AGL - CSG CAMDEN GAS PROJECT NORTHERN EXPANSION

Project Application No. - 09\_0048

Project Title - AGL Camden Gas Project, Northern Expansion

AGL Documents - Environmental Assessment, October 2010  
 Submissions Report, October 2012

LAND USE CONTEXT  
 Submissions Report  
 Camden Gas Project Northern Expansion

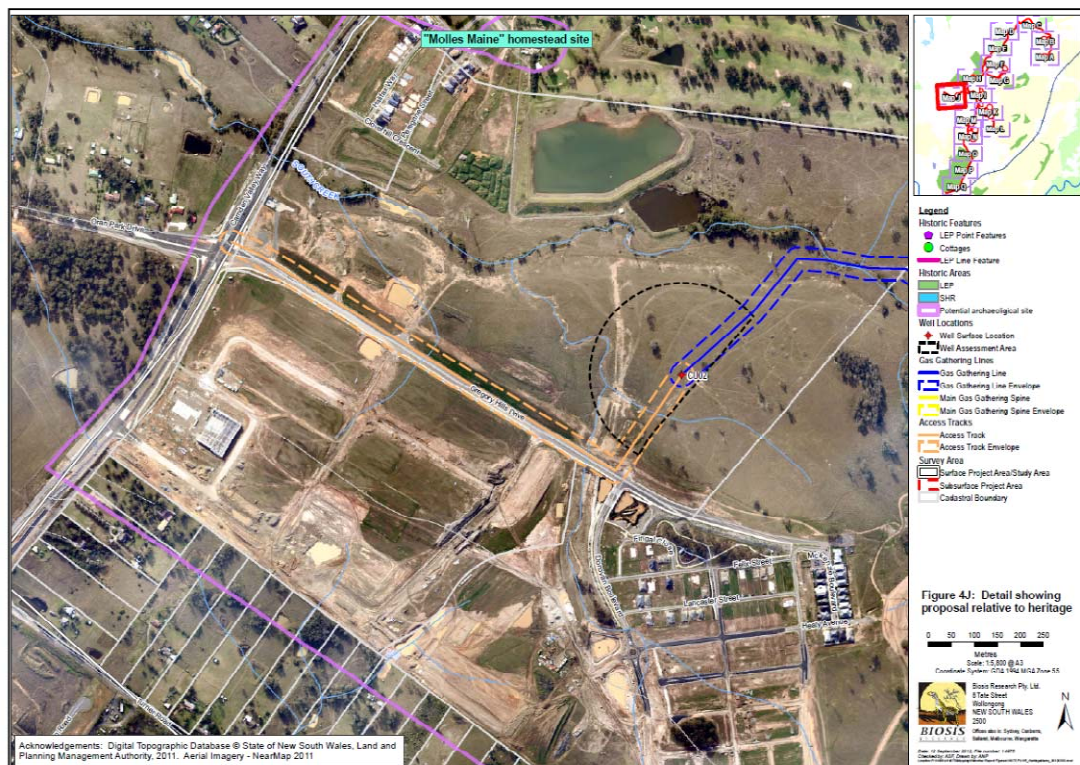
And at FIGURE 3, AECOM AMENDED PROJECT LAYOUT, and FIGURE 7, AECOM LAND USE CONTEXT map MAIN REPORT and APPENDIX A-F 2012 the street patterns of Gregory Hills Residential Estate and the Hermitage are missing - the AECOM Consultants have had 2 years to get this map up to date. There is no excuse for this omission. In fact all the maps have not been updated with the new street patterns of new suburbs. This continues the false impression that the AGL-CSG wells are in broad greenfield zones. Nothing is further from the truth.
